DOC18/199953-01
SSD 8778

**SSD 8778 – GREYSTANES PUBLIC SCHOOL RE-DEVELOPMENT – ENVIRONMENTAL
IMPACT STATEMENT (EIS)**

- ENVIRONMENT PROTECTION AUTHORITY COMMENTS -

GREYSTANES PUBLIC SCHOOL RE-DEVELOPMENT

Appendix B Daily noise survey data

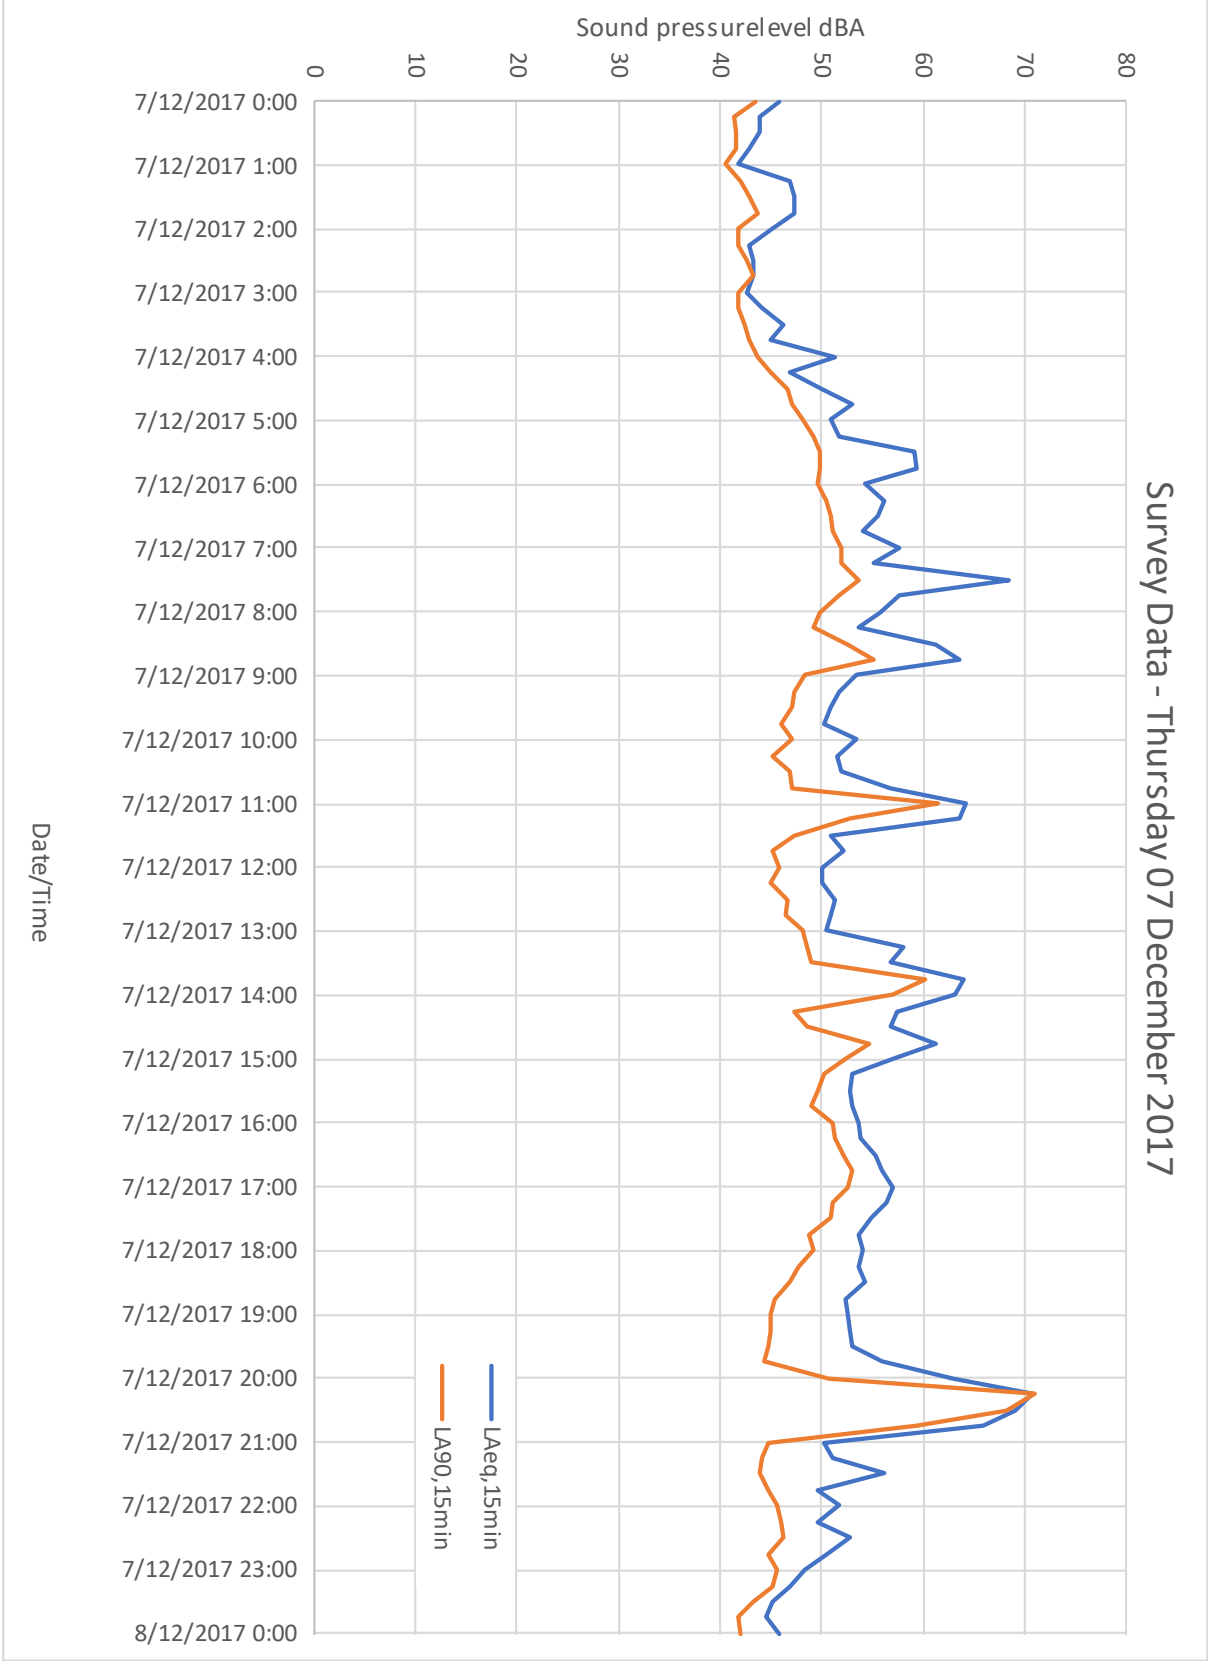
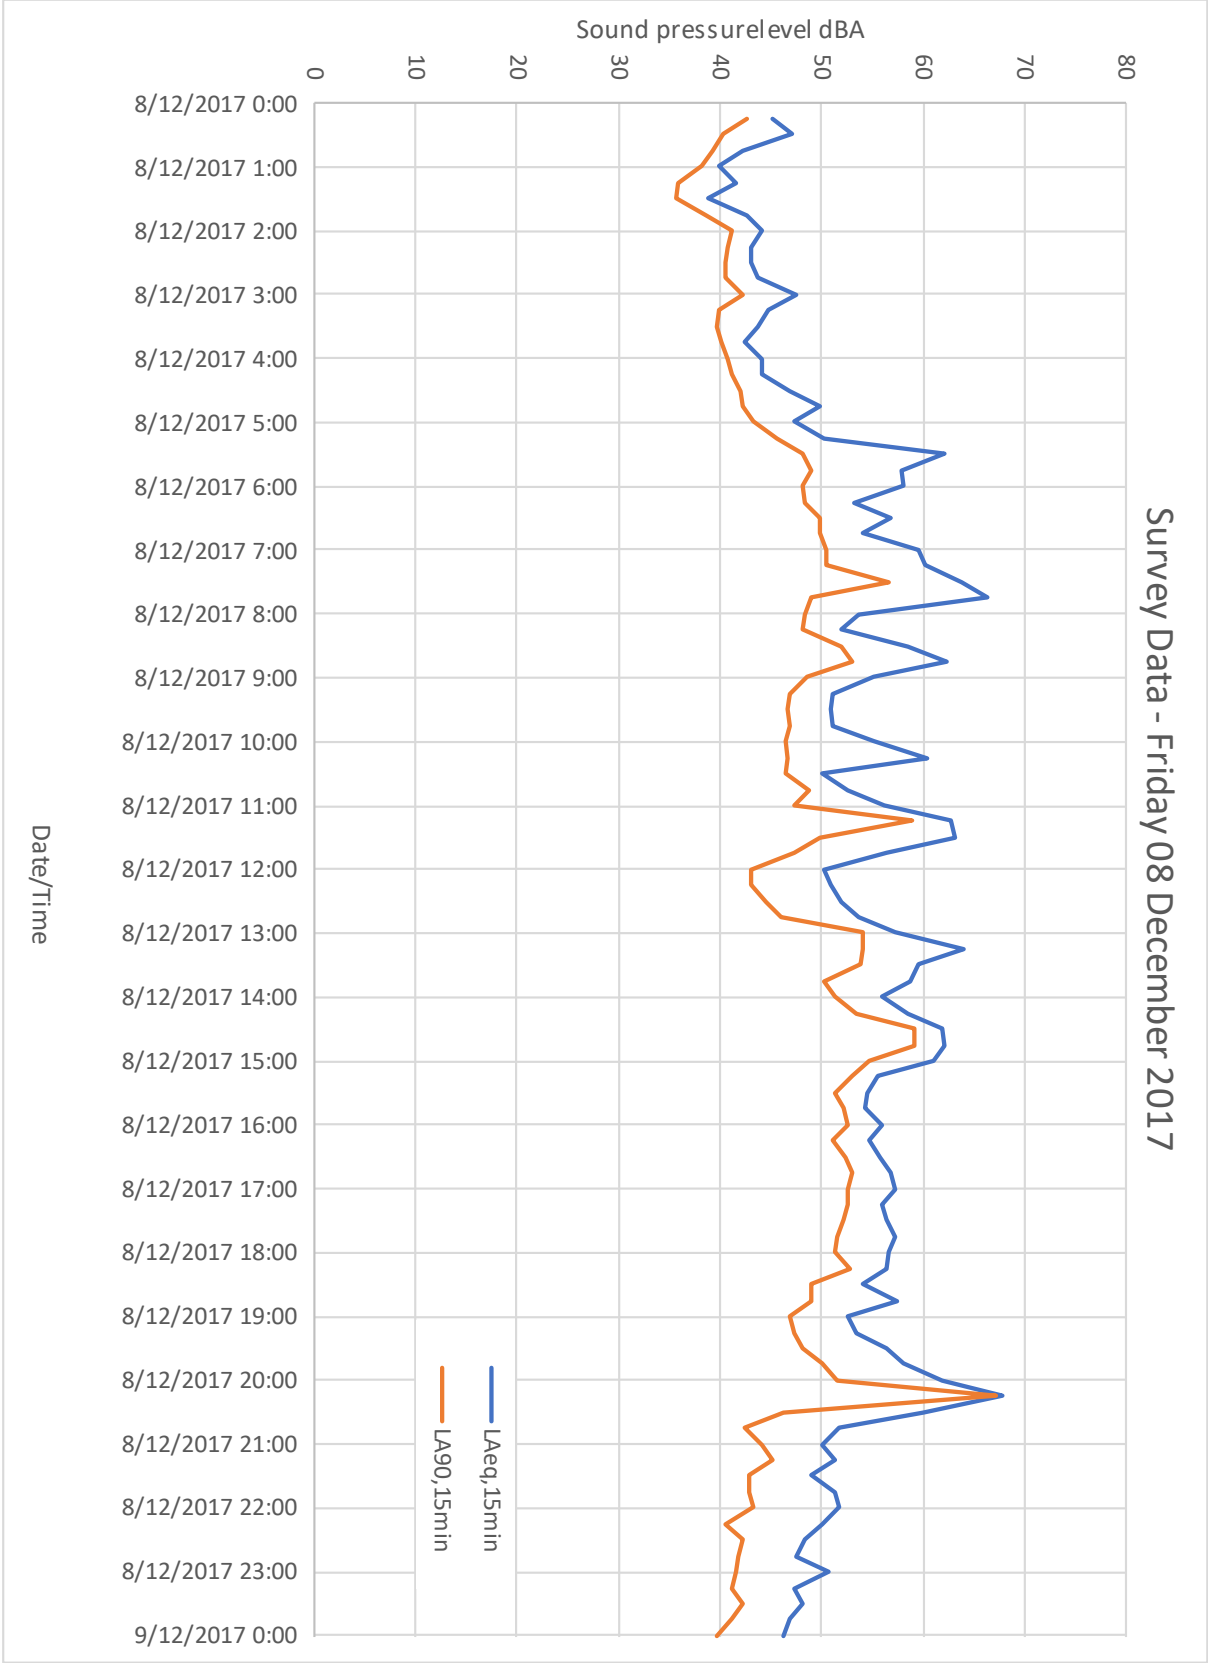
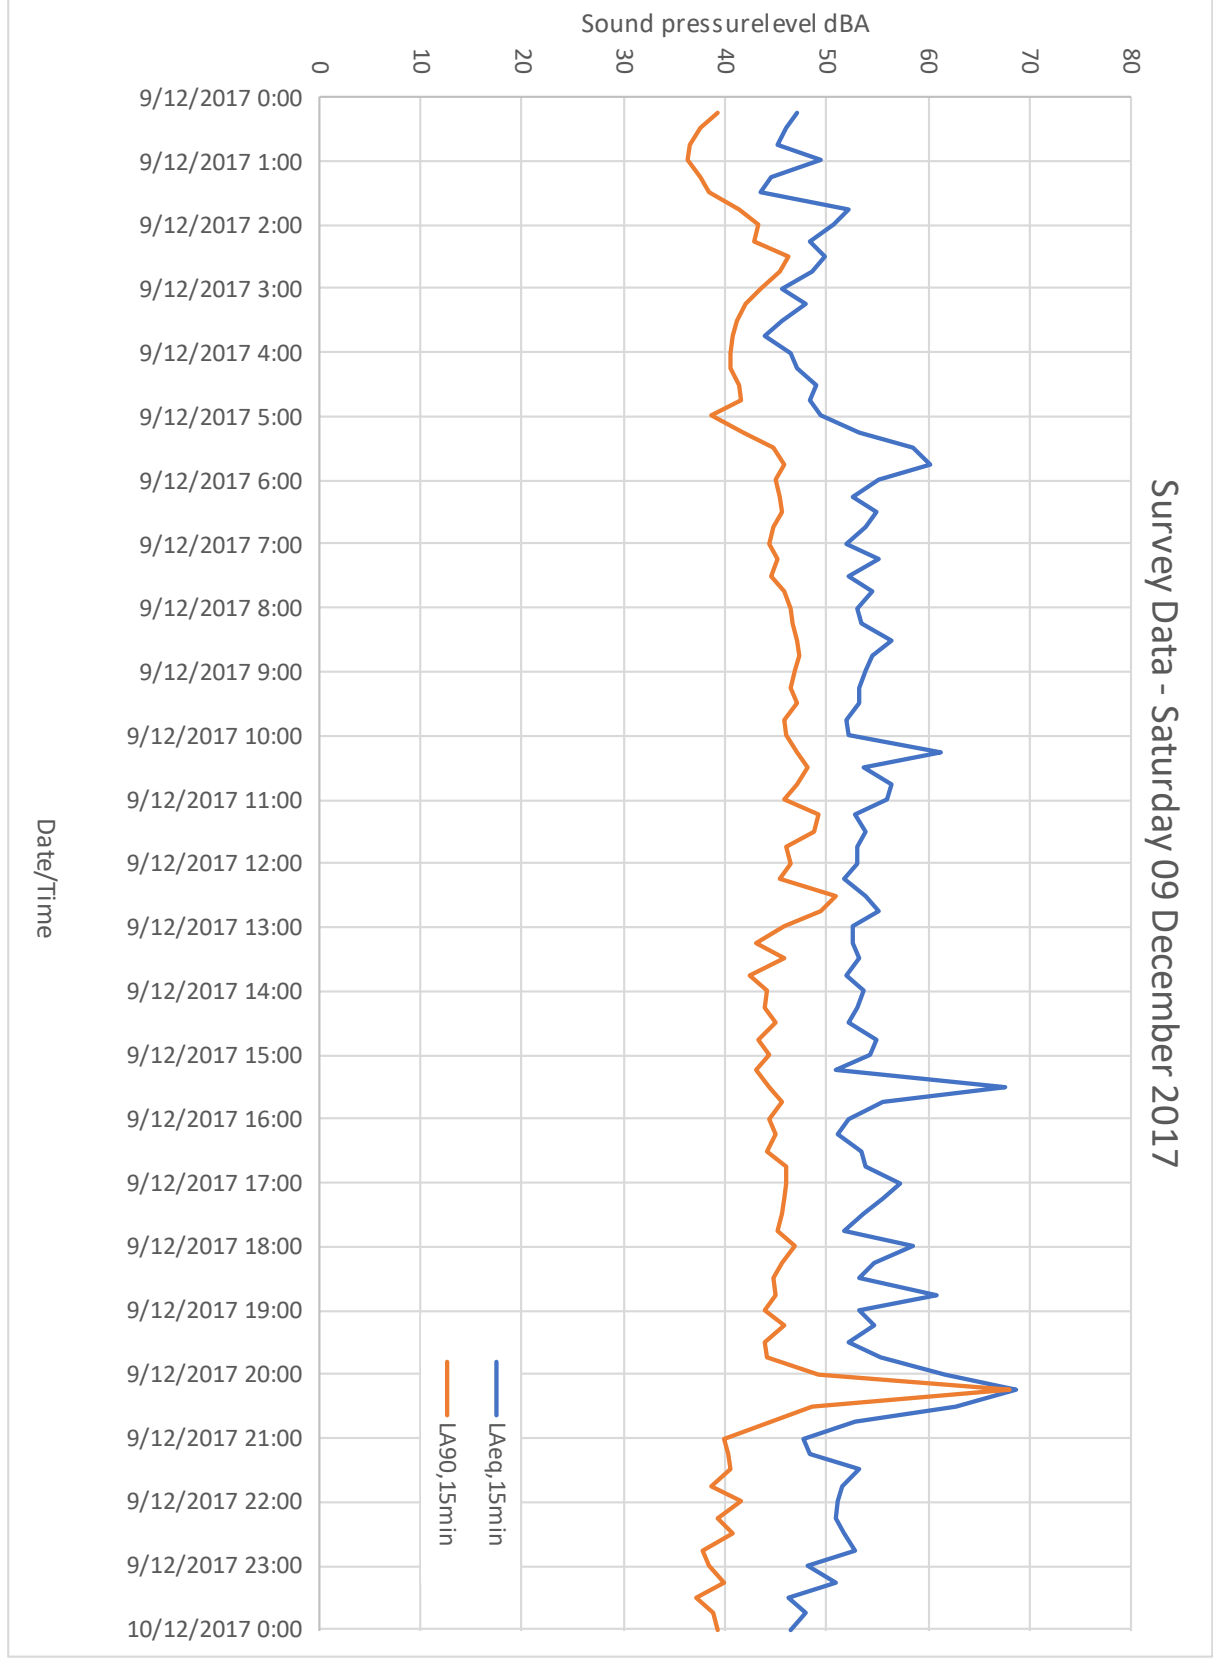
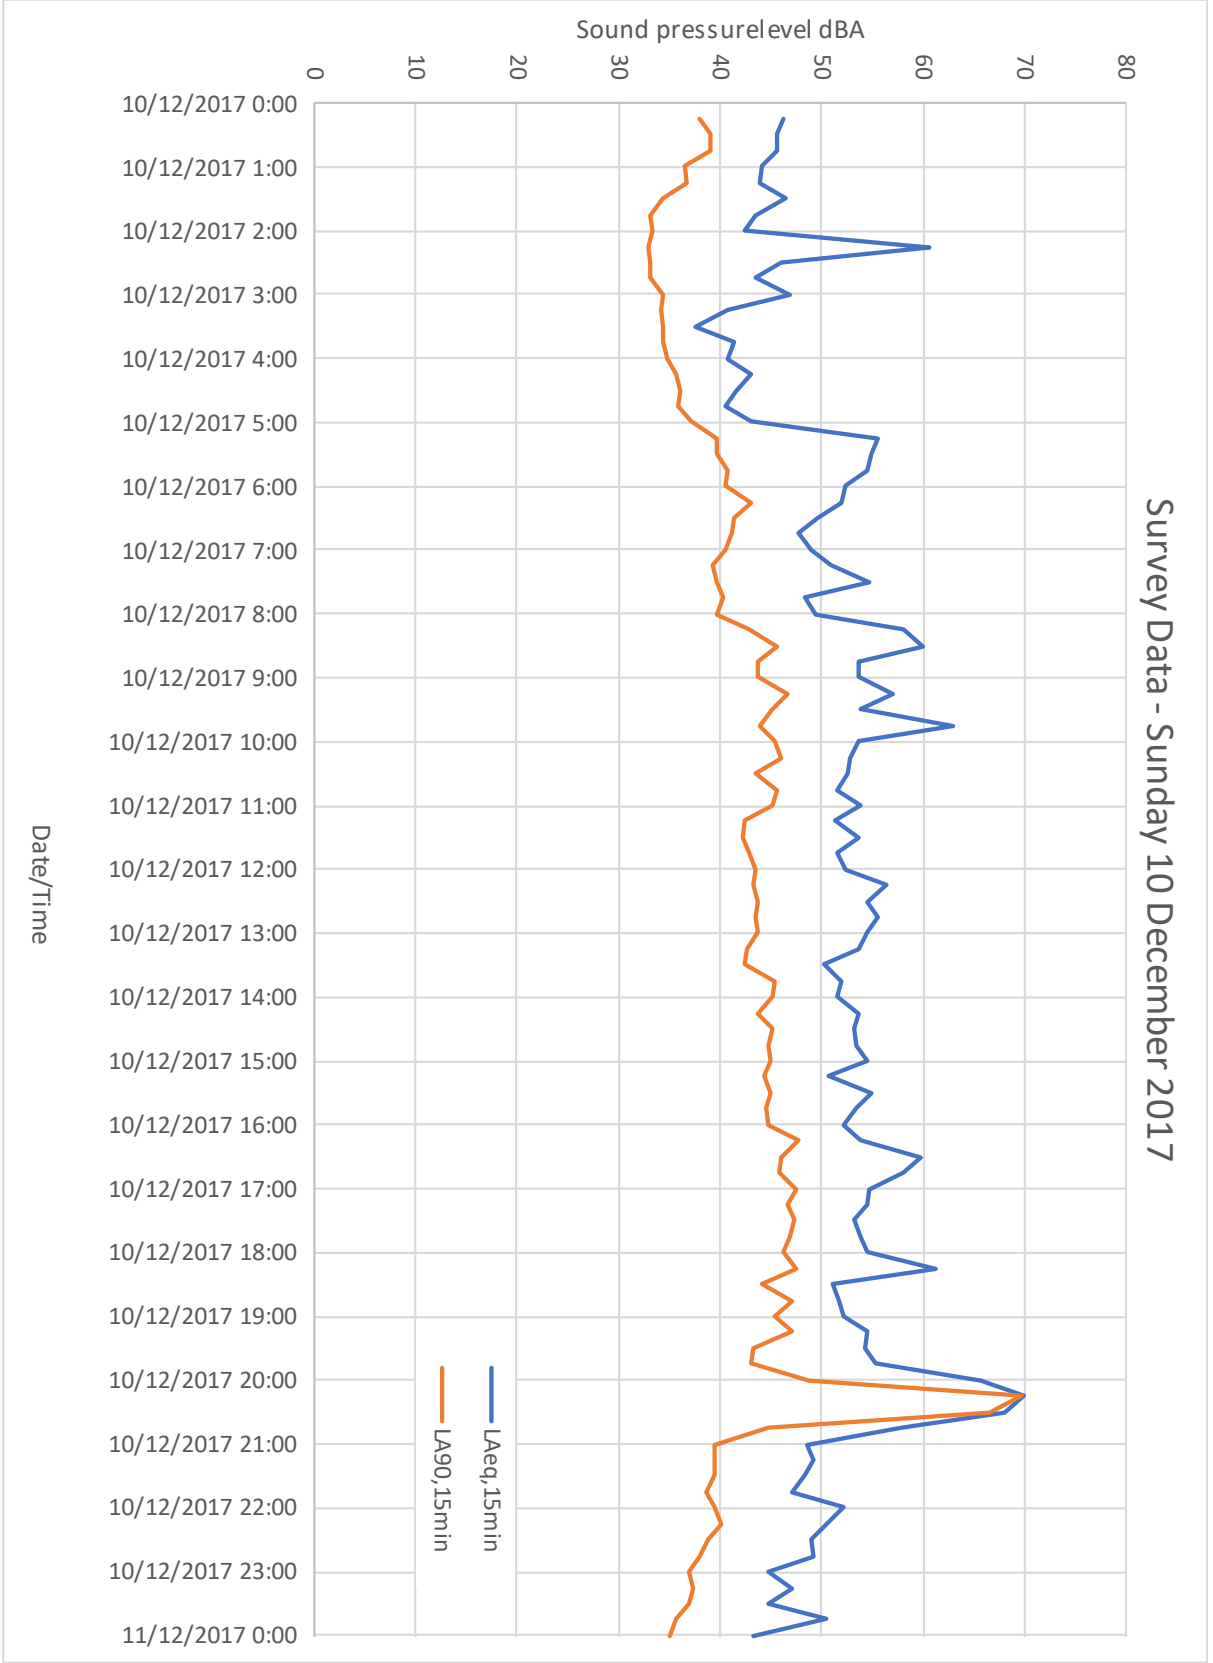
The EPA further notes that graphical presentations in Appendix B (to EIS Appendix 14) clearly show that the December 2017 background noise monitoring results are affected by a specific source or sources (extraneous noise) at specific times of the days. Importantly, those effects are not considered in Appendix 14.

The EPA recommends DPE require the proponent to establish background noise levels in accordance with the requirements of the INP.

The proponent be required to properly establish the background noise level for the locality for each assessment period (i.e. day, evening, night) in accordance with the guidance provided in the New South Wales Industrial Noise Policy.
